COMMUNITY SERVICES DEPARTMENT
PARK OPERATIONS ~ PLANNING ~ CSU EXTENSION ~ COMMUNITY OUTREACH
ENVIRONMENTAL SERVICES ~ VETERANS SERVICES ~ RECREATION/CULTURAL SERVICES

August 14, 2017

Subject: Lorson Ranch East PUD/Preliminary Plan (PUDSP-16-003) Review 1

TRACTS/ OPEN SPACE AREA:

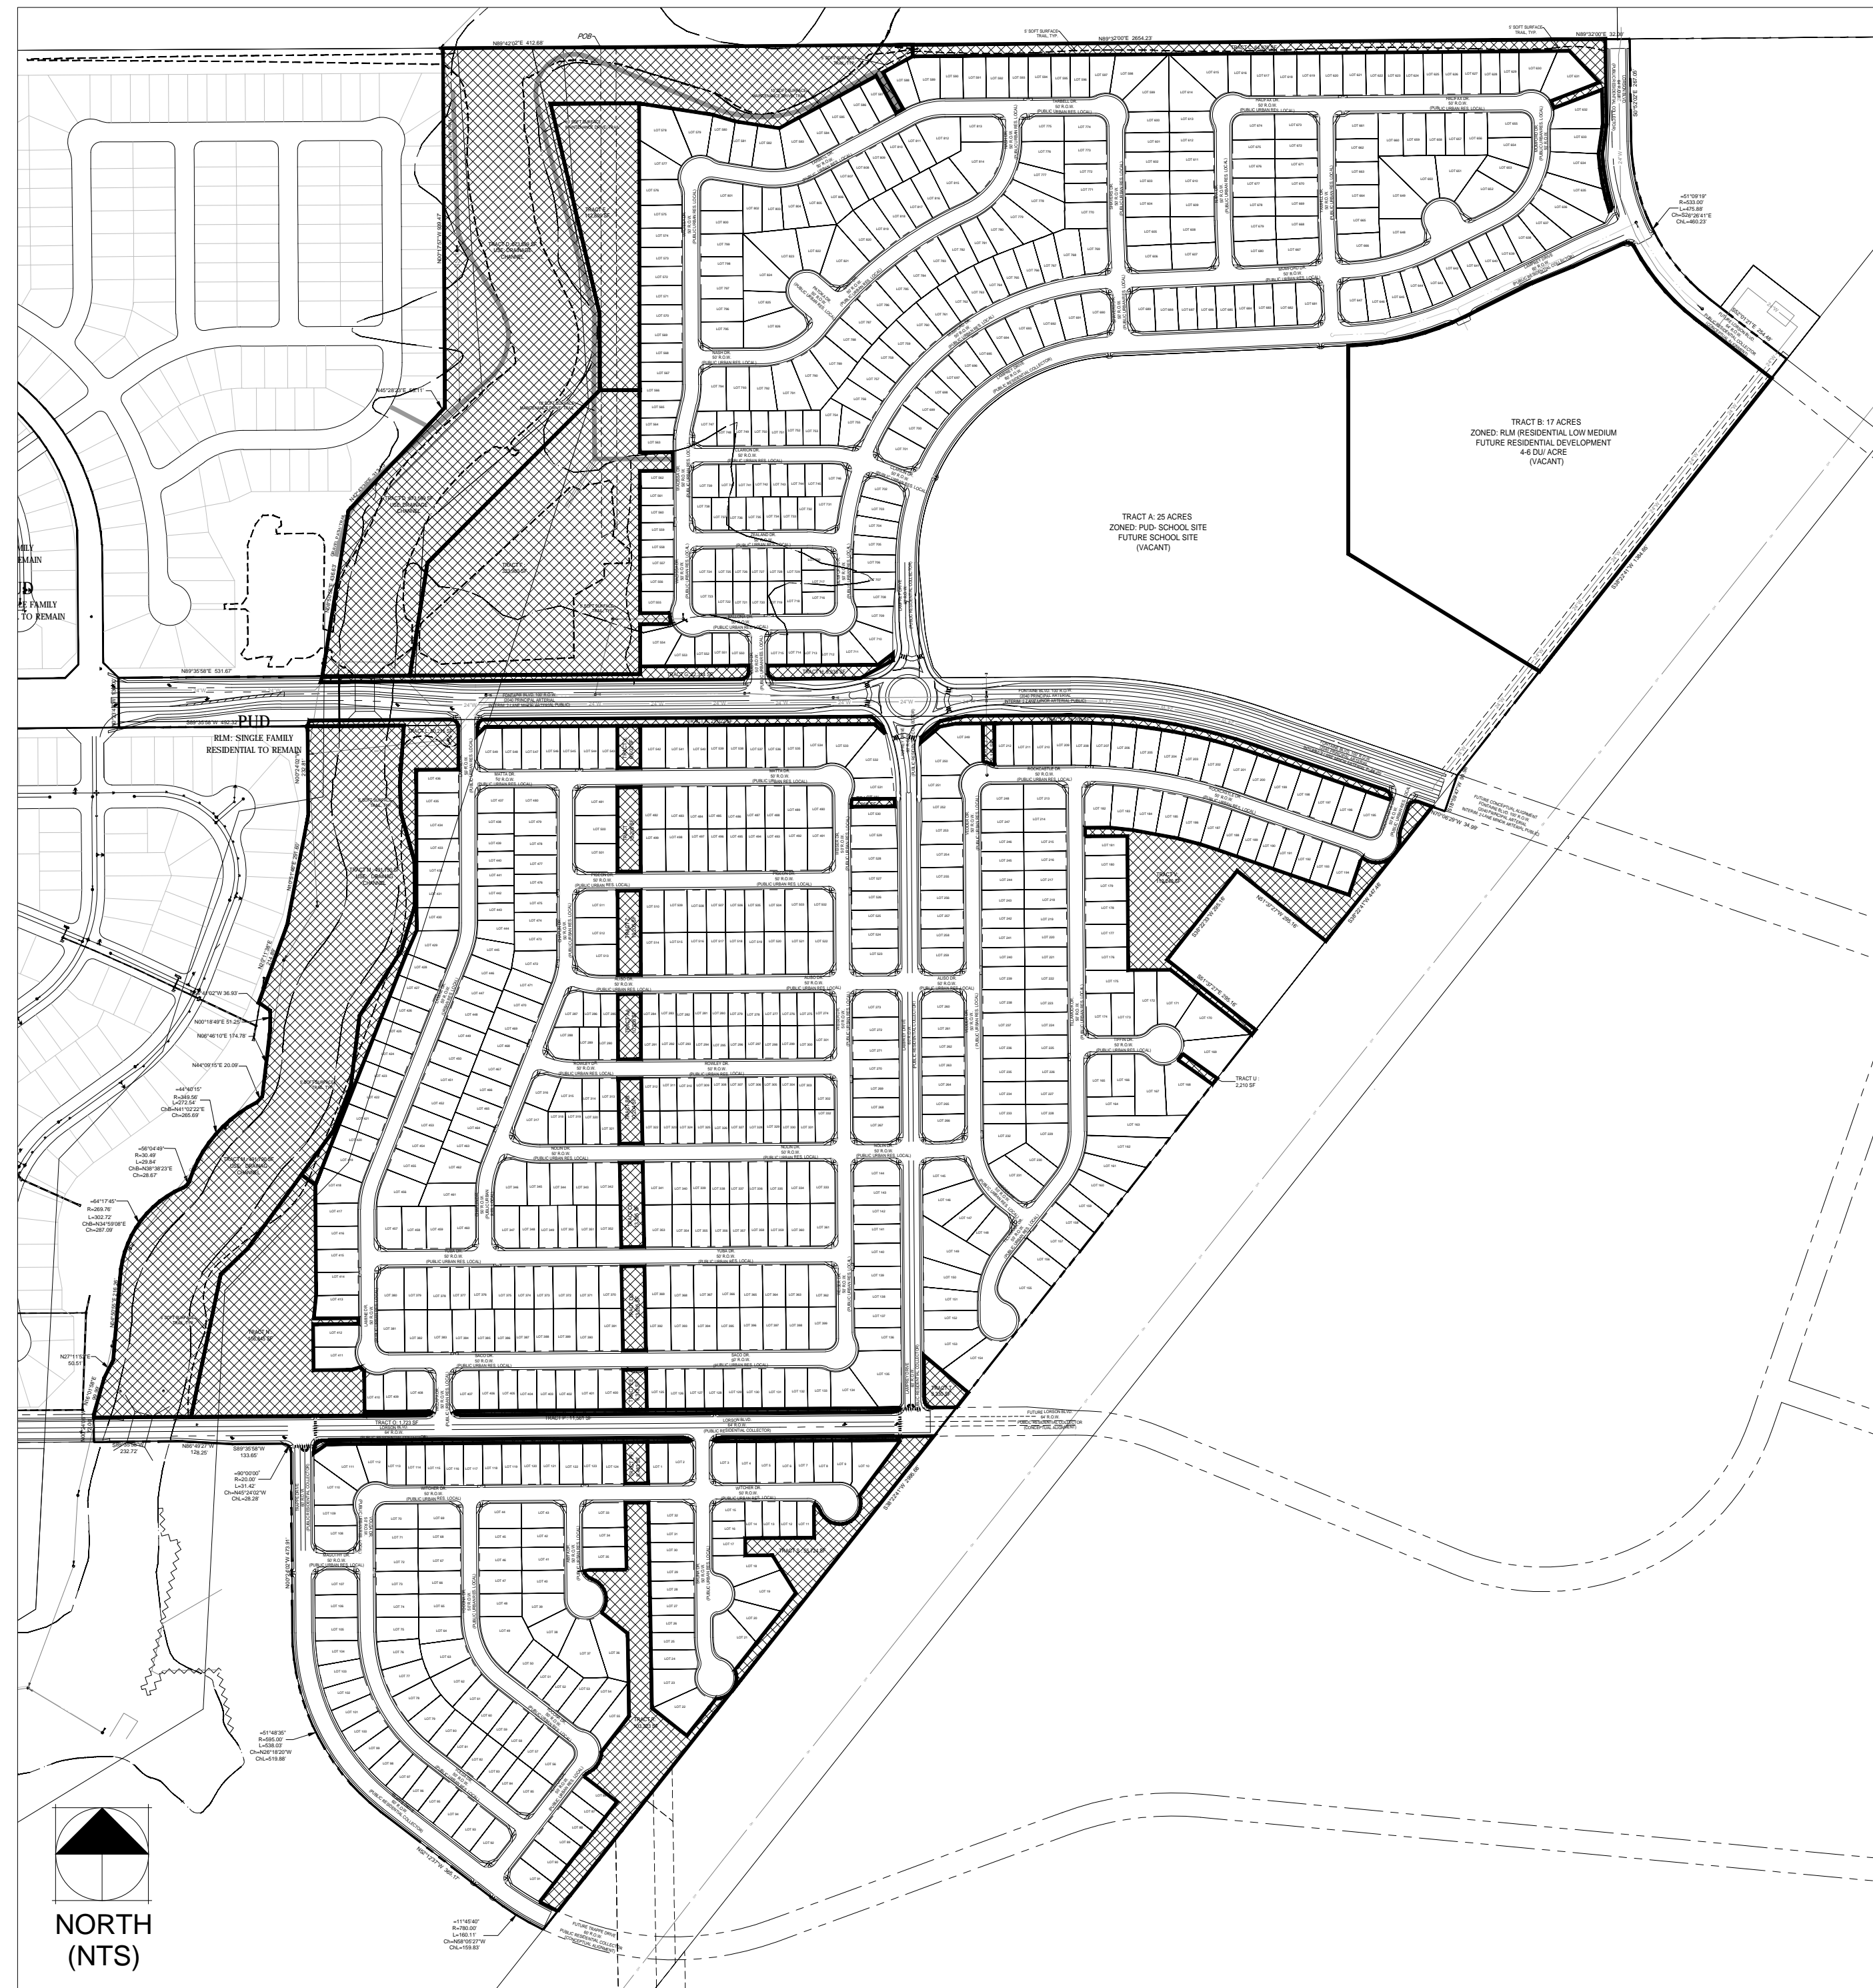
The overall project site was increased by 48.83 acres, from 225.76 acres to 274.59 acres. Open space dedication was also adjusted and now includes 53.98 acres, or 19.7% of the project site. This exceeds the 10% minimum required for PUD zoning, but represents a reduction in open space dedication from the previously submitted application. The original PUDSP provided 48.95 acres, or 21.7% of the project site as open space. Staff requests the applicant provide an additional 5.61 acres of open space, totaling 59.59 acres, to provide the same open space dedication as originally submitted.
